WEST SUSSEX COUNTY COUNCIL CONSULTATION

TO:	Arun District Council FAO: Zac Denton
FROM:	Highways, WSCC
DATE:	16/01/2019
LOCATION:	98 Elmer Road, Middleton-on-Sea, PO22 6LJ
SUBJECT:	M/135/8/HH To extend the dropped curb across the whole of the driveway at the front of the house to enable additional off-street parking.
DATE OF SITE VISIT:	N/A
RECOMMENDATION:	☒ Advice ☐ Objection ☐ Modification ☐ No Objection ☐ More Information ☐ Refusal
S106 CONTRIBUTION TOTAL:	£N/A

18/10/29
GROUND FLOOR
1:100 @ A3

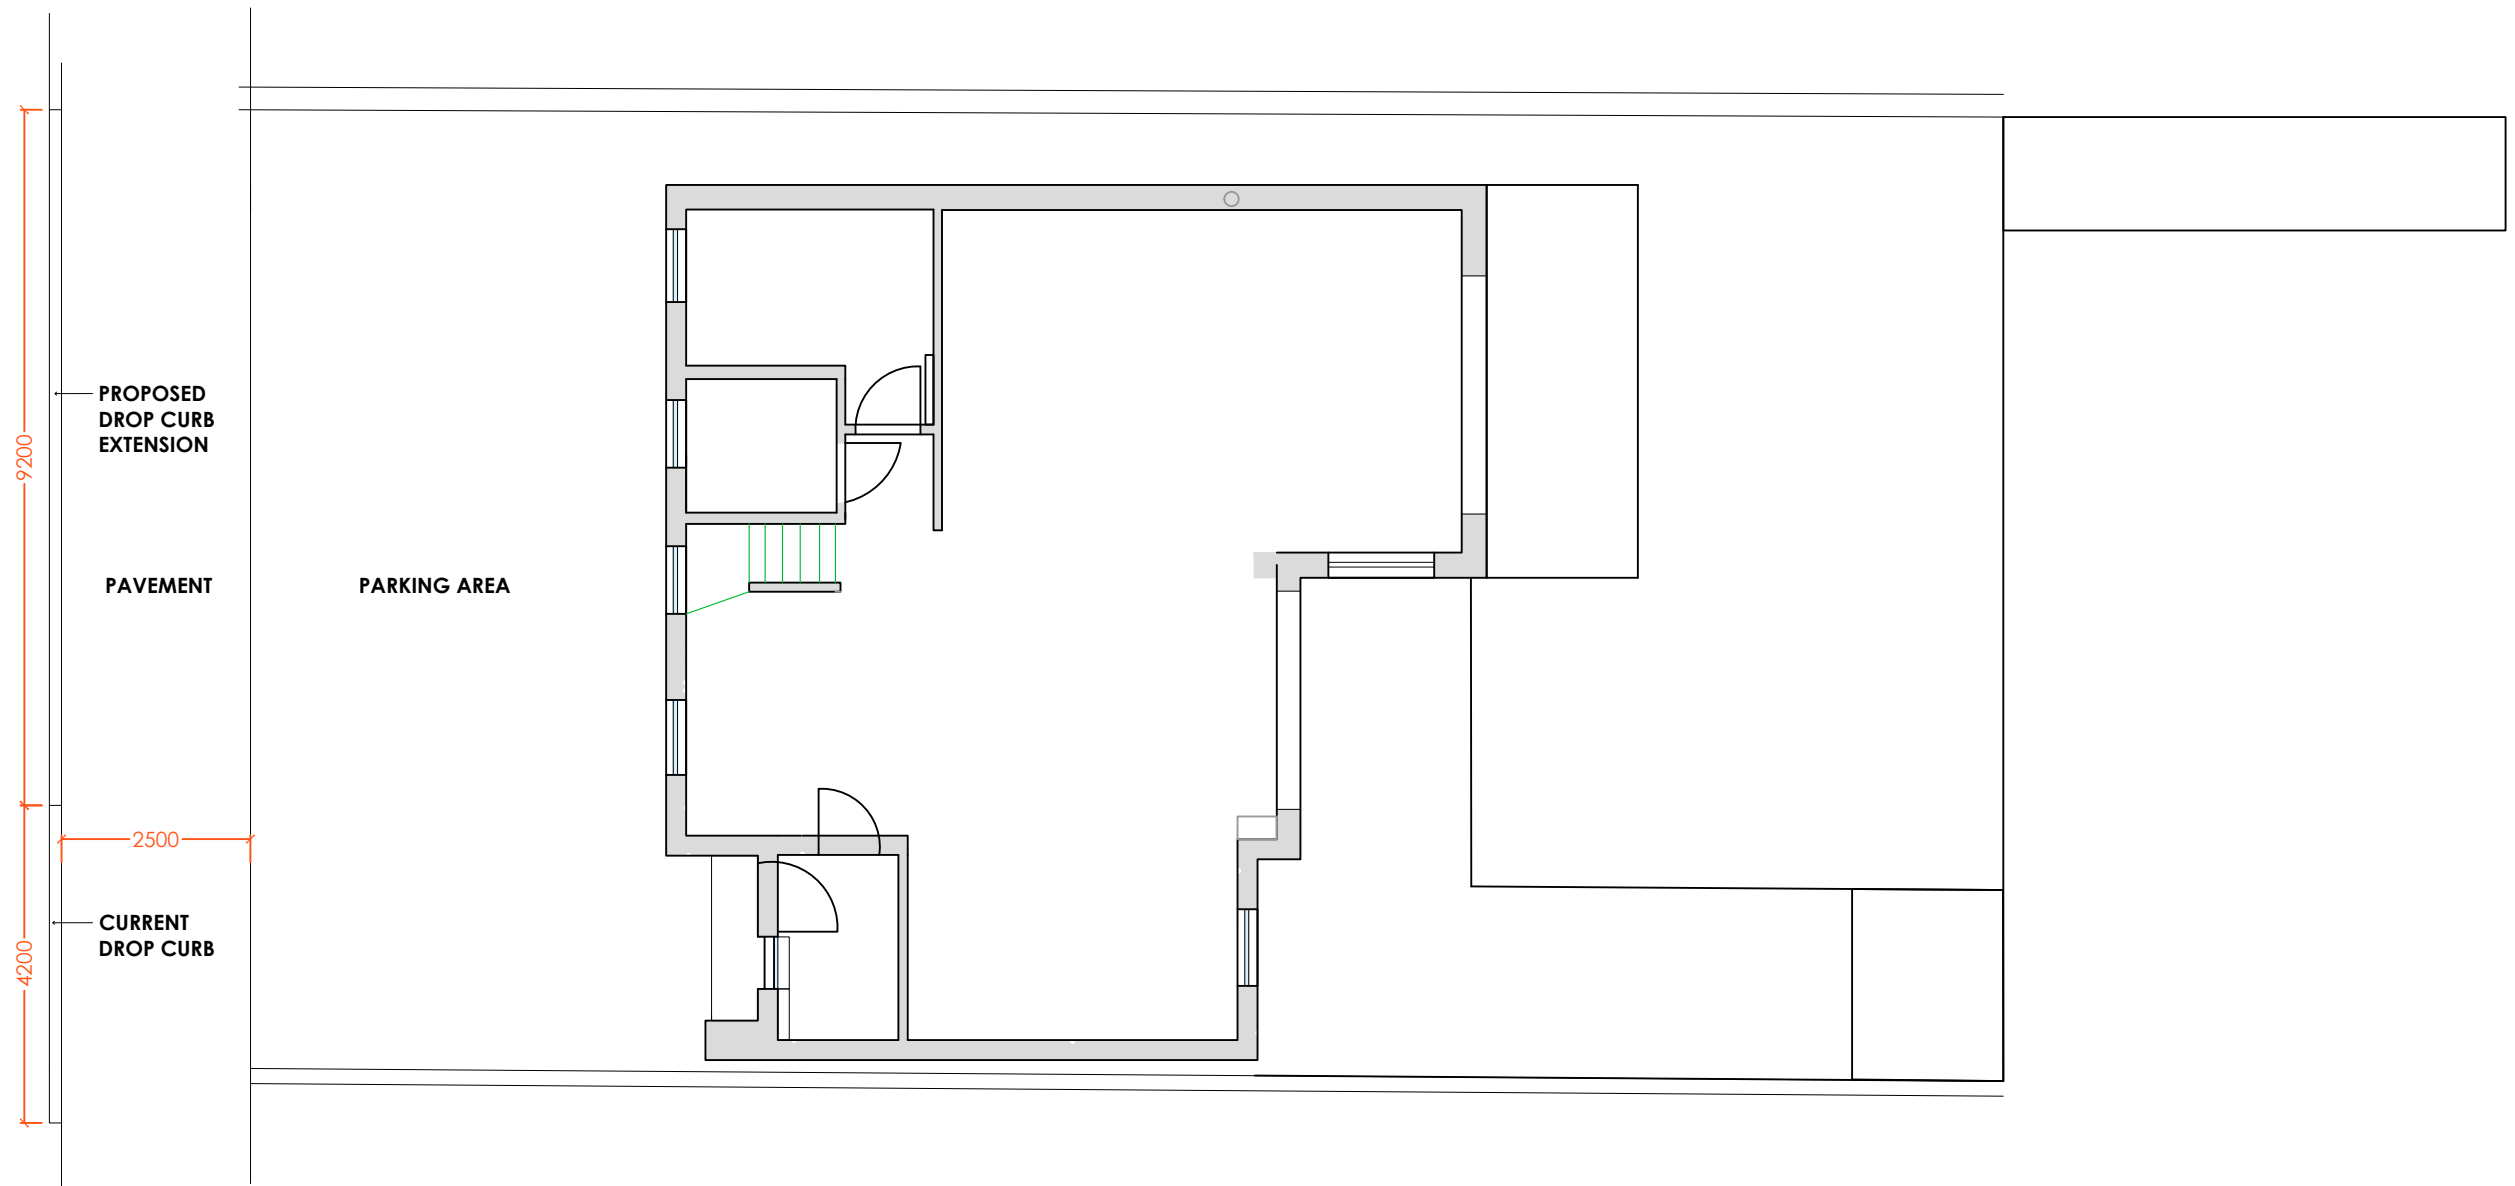
The provided plans indicate that the site currently benefits from an existing 4.2m VCO. The plans propose to widen this across the whole site frontage to a total width of 13.2m. A licence will be required for the proposed VCO works onto Elmer Road. The applicant should be aware that the Local Area Engineer is unlikely to grant a licence for a VCO of wider than 6.4m in this location.

The applicant has provided a visibility splay plan however this has been drawn in only one direction at the proposed access and has been drawn to a distance of 70m. Manual for Streets sets out a minimum stopping sight distance of 43m at a distance of 2.4m back from the carriageway edge for a 30mph road. An inspection of WSCC mapping indicates that these splays are achievable at this location are maintainable wholly within the Highway Boundary.

A parking layout plan has not been provided, however the proposed plan indicates that a number of vehicles would be able to park on the site frontage as result of this proposal. A turn on site would be preferred however; there is insufficient space on site to accommodate this and this appears to be the existing practice in this location which has been operating for some time without evidence of safety concern. The parking area should be constructed from a hardbound material. If the applicant intends to construct the parking area from gravel, a gravel trap or area of block paving, or other bound material, should be provided at the point of access onto Elmer Road (on land within the applicant's control; not within the publicly maintained highway).

The use of the access shall not commence until such time as the parking area has been constructed in accordance with the details shown on the drawing titled Ground Floor and numbered 18/10/29.

The use of the parking area shall not commence until such time as the vehicular access serving the dwelling has been constructed in accordance with the details has been provided shown on the drawing titled Ground Floor and numbered 18/10/29. These spaces shall thereafter be retained at all times for their designated purpose.
